**WELWYN HATFIELD BOROUGH COUNCIL – DEVELOPMENT MANAGEMENT**  
**DELEGATED REPORT**

<b>APPLICATION No:</b>	<b>N6/2012/1700/FP</b>
<b>APPLICATION Site:</b>	<b>34 Sherrardspark Road</b>

**DESCRIPTION OF PROPOSAL:**

INCREASE WIDTH OF
CROSSOVER TO 4.8M

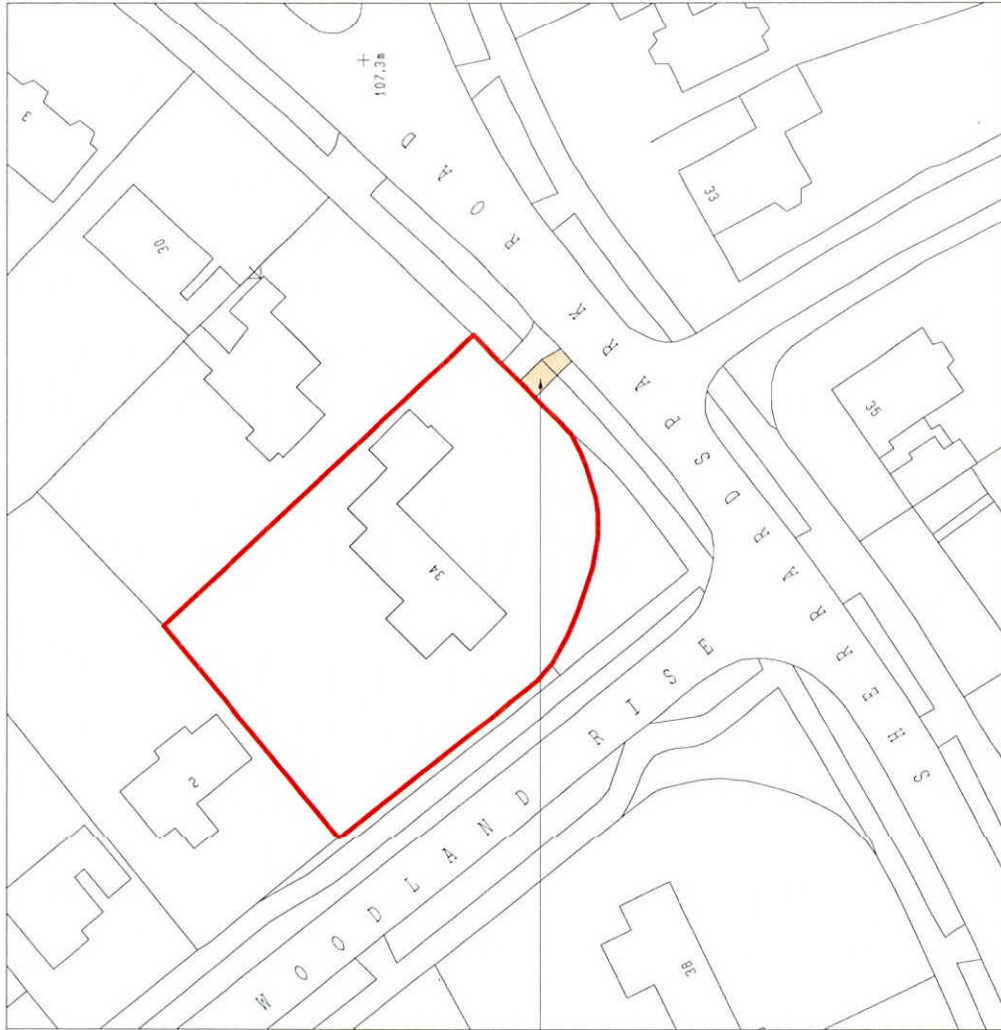
The extension of a vehicle crossover would not require planning permission as this is a proposed extension of an existing crossover and not the formation, laying out or construction of a means of access to a classified road or trunk road in accordance with part 2, schedule 2 of The Town and Country Planning (General Permitted Development) Order 1995.

1. This planning decision does not include the approval and carrying out of works regarding the increased width of crossover. The applicant would need to contact Hertfordshire County Council Highway Authority to apply for these amendments.

Drawing Title
 PROPOSED PLANS
 & ELEVATIONS

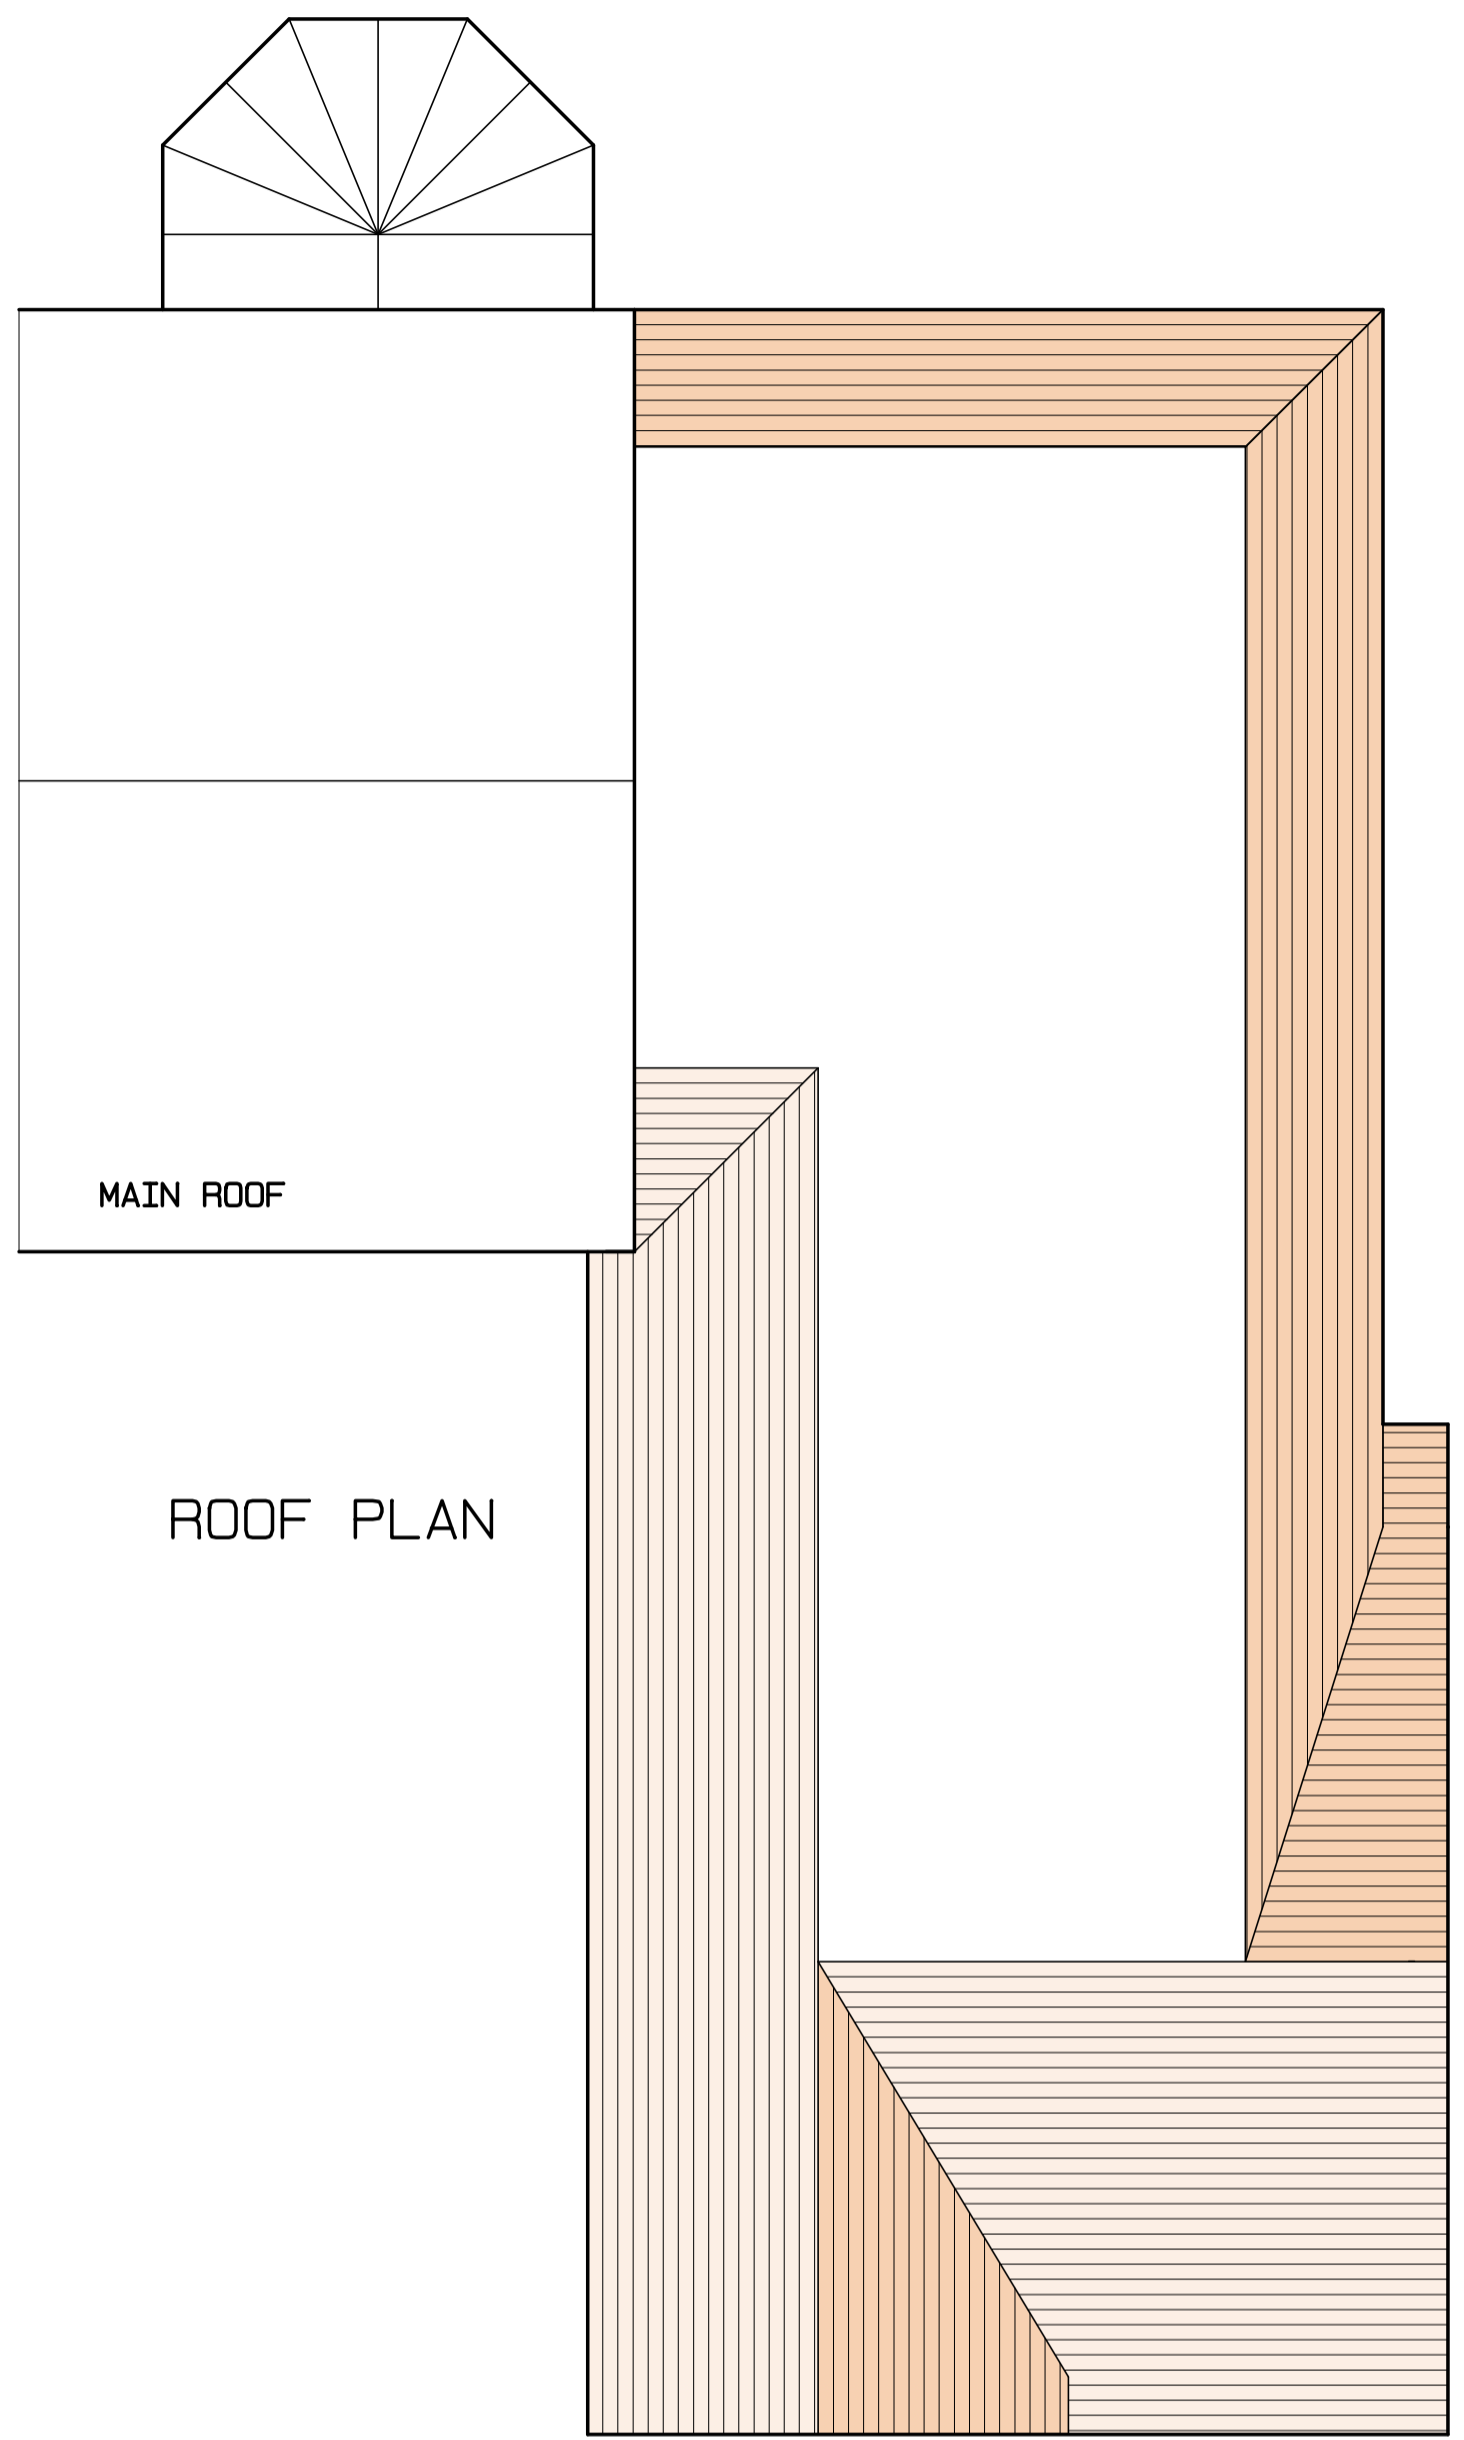
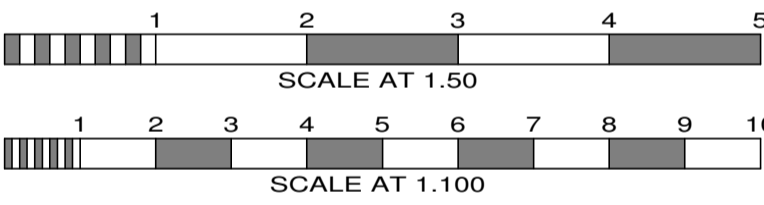
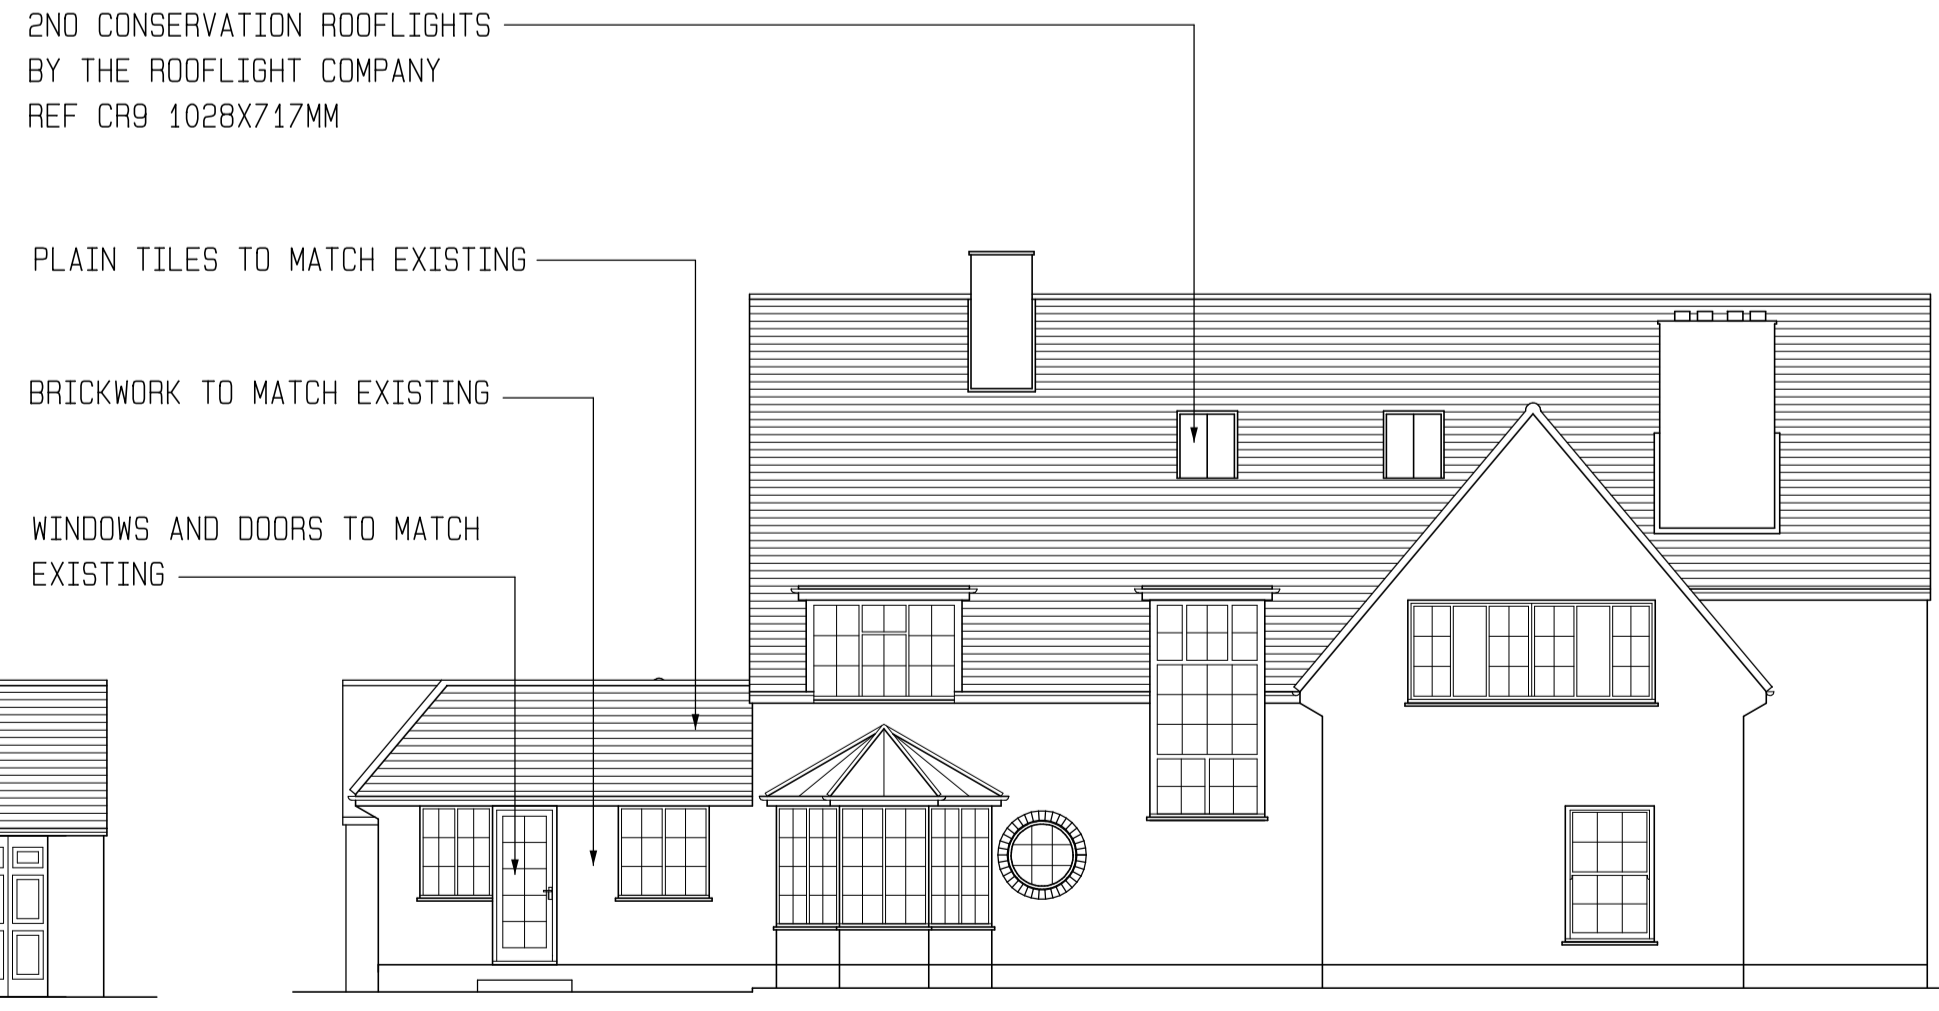
The proposal would be relatively minor in scale and clearly subordinate against the original dwelling, despite alterations to the rear, side and frontage. The approximate increase in foot space would only be 20% against the existing ground floor level. The garage alterations, whilst forming a large structure for a single garage, would be proportionate in relation to the existing dwelling.

In regards to the architectural design, the proposal is considered to reflect the design and character of the original dwelling. The rear extension would be modest in scale and corresponding in design, whilst the side extension would be visually unassuming and would also harmonise architecturally with the existing dwelling.

The garage, whilst only adding minor bulk, would create a greater visual impact, particularly as it is located at the front of the property and would be the most forward facing aspect of the dwelling. However, in relation to the scale of the existing dwelling, it would be proportionate in size, would correlate in design and would retain the existing roof line. It is therefore considered appropriate development.

The proposal also includes two rear sky lights. These are not considered to be in keeping with the architectural design of the dwelling. However, the development is only minor in scale and would be visually concealed from the street scene.

The property most likely to be materially impacted as a result of the development would be the immediate neighbours of 32 Sherrardspark Road. The side extension

to the property would be adjacent to the boundary between these two properties. It is proposed to maintain a 1m gap between the development and the boundary line, which whilst minimal, is considered appropriate.

There is the potential for an impact on outlook from the positioning of the side extension. Again however, due to the size and scale of the development, these concerns would not be considered substantial enough to warrant refusal.
